Statement of Common Ground with Beverley and North Holderness Internal Drainage Board (draft)

Revision 2

September 2025

- 1.1.2 The DCO Application is for a Nationally Significant Infrastructure Project (NSIP) for the construction, operation (including maintenance) and decommissioning of a solar photovoltaic (PV) array electricity generating facility, Battery Energy Storage System (BESS) and associated infrastructure which would allow for the generation and export of electricity.

Typical access track cross section

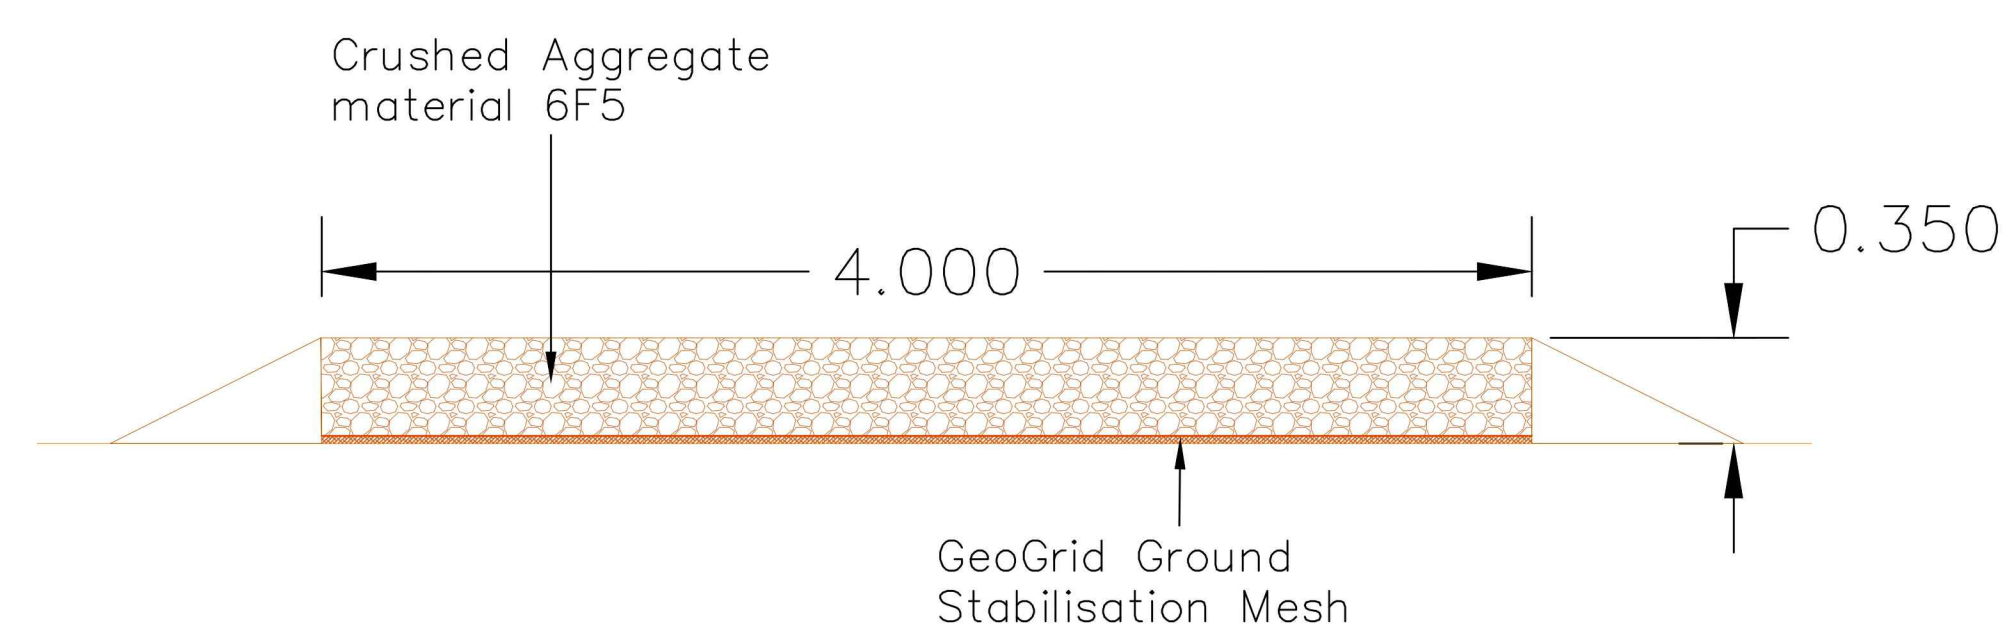
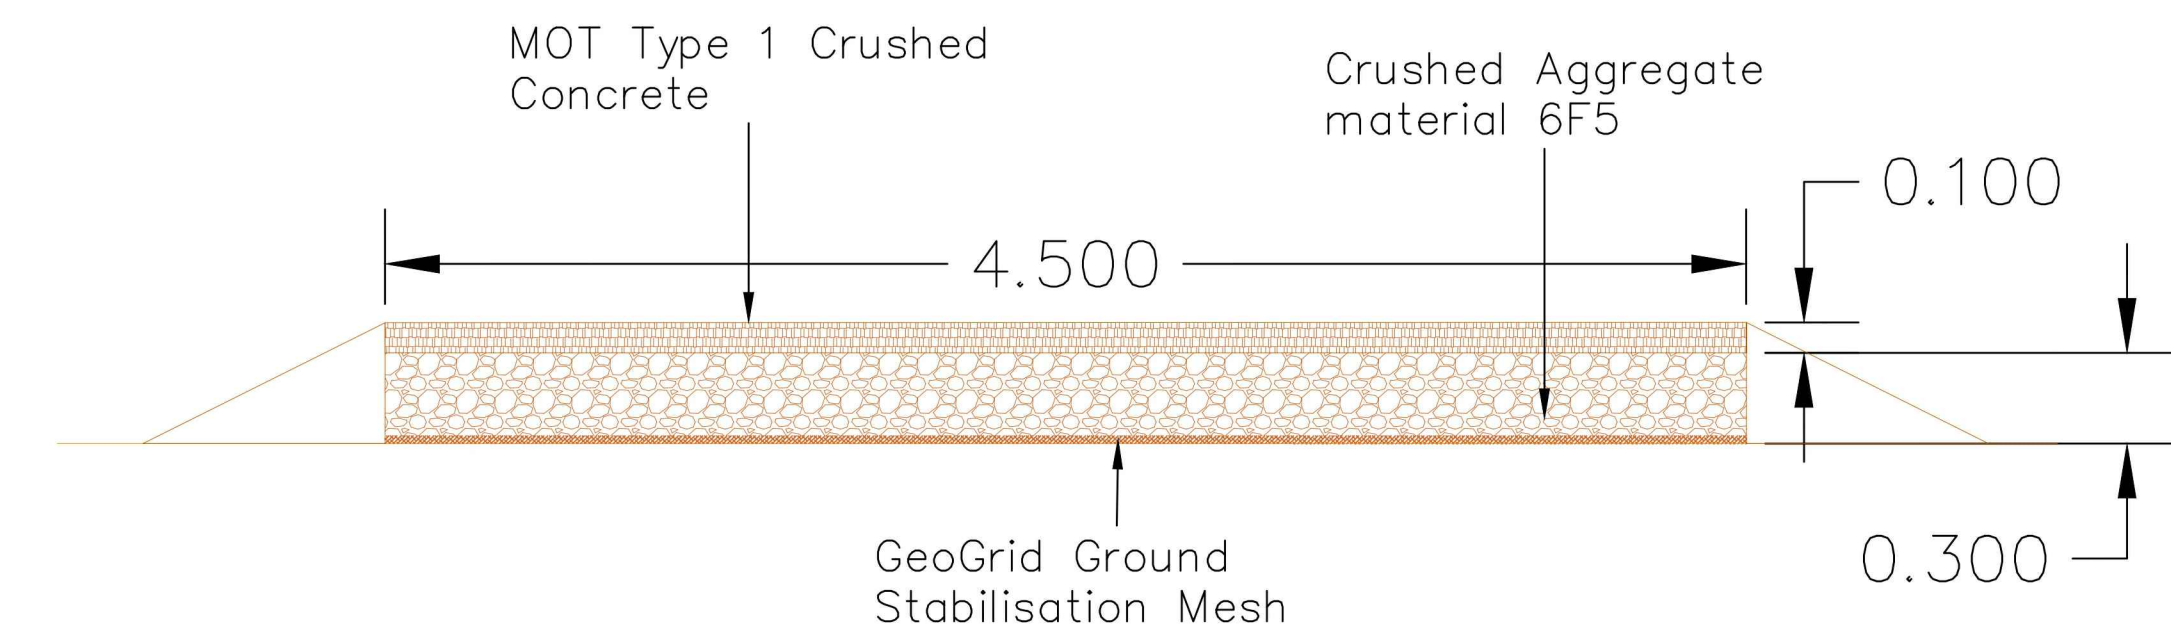
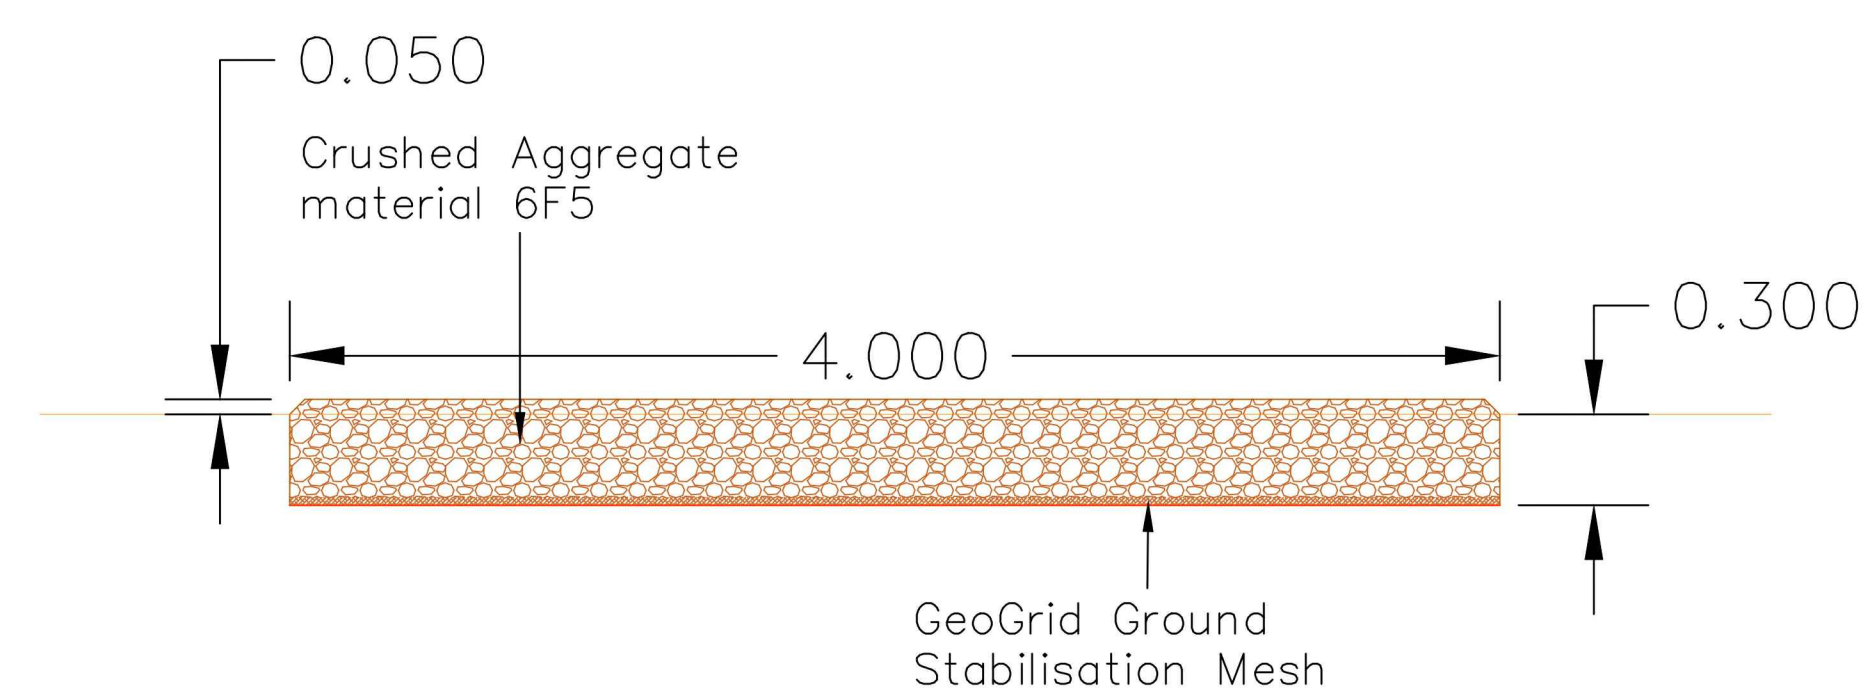
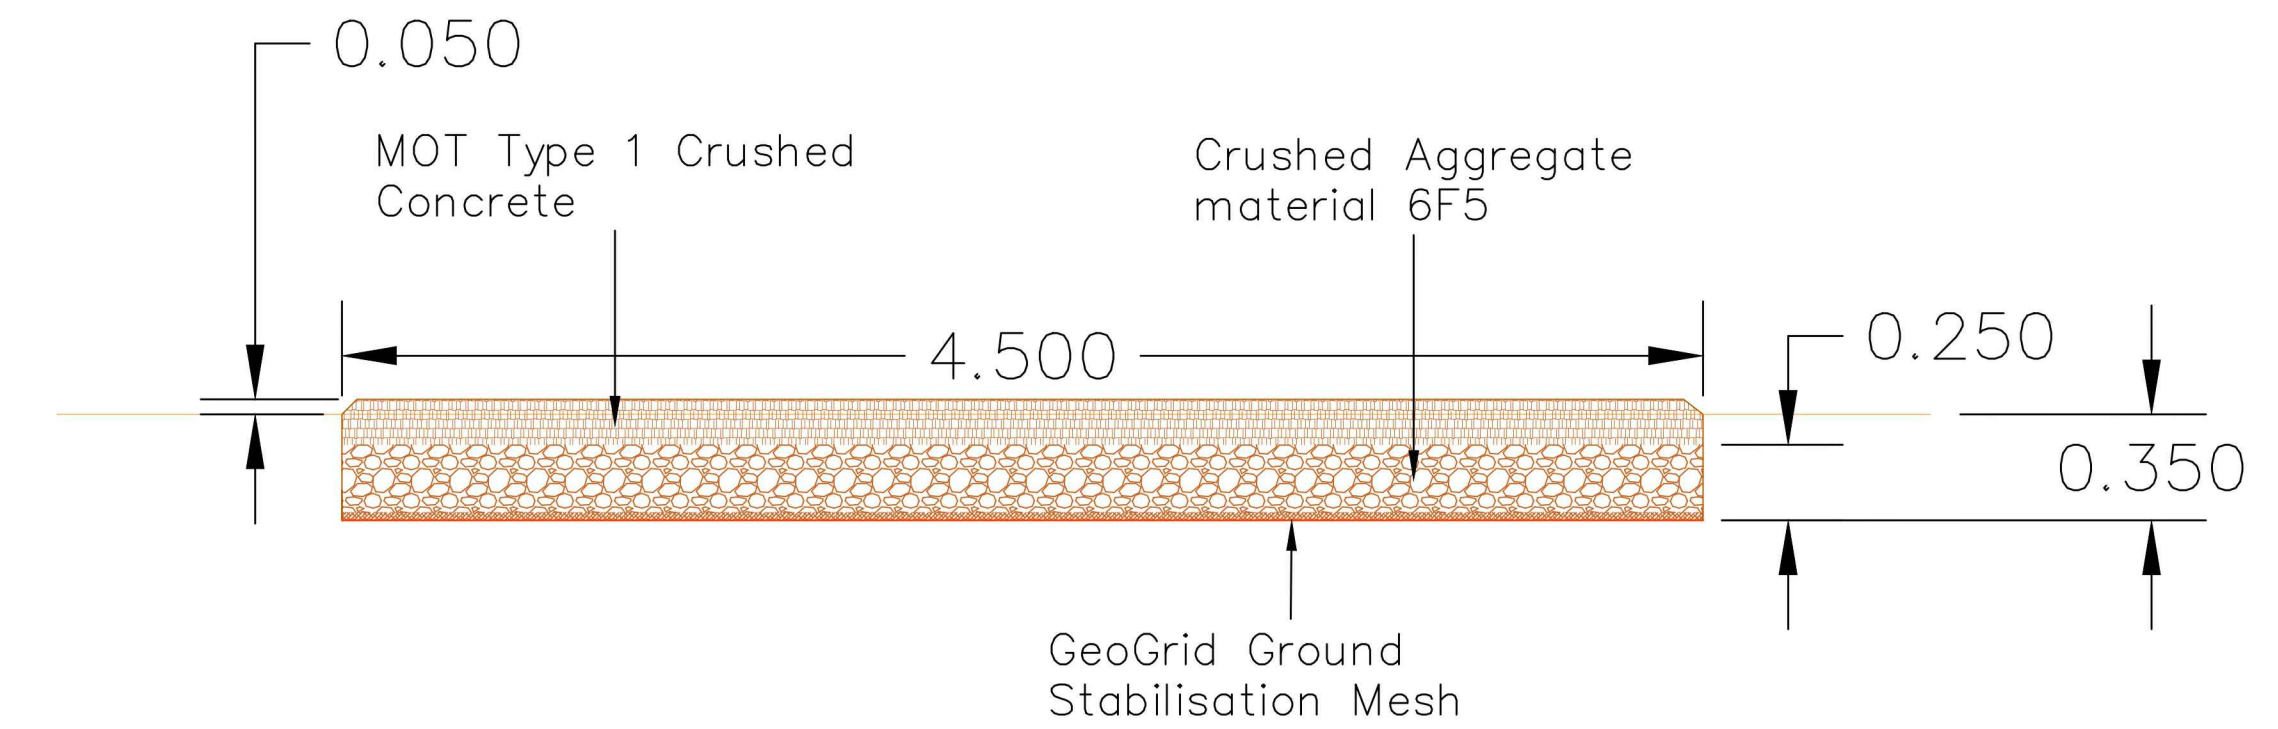
IDB02	Access tracks <i>Hydrology and Flood Risk</i>	In its relevant representation [RR-004] , Beverley and North Holderness Internal Drainage Board states that if Type 3 material (with a 30% voids ratio) is used for access tracks, this is viewed as "permeable" and not requiring a drainage strategy. If Type 1 materials or other impermeable materials are used, this is viewed as "impermeable" and requiring a drainage strategy.	Internal access track design, including materials, will be confirmed as part of the detailed design stage and submitted to East Riding of Yorkshire Council for approval as part of Requirement 3 of the Draft DCO [EN010157/APP/3.1 Revision 4] . The Applicant will continue to liaise with the Board on this matter.	Under discussion
IDB03	Bridge/culvert	In its relevant representation [RR-004] , Beverley and North Holderness Internal	The Applicant agrees to this request. It is the Applicant's intention to utilise existing culvert	Agreed
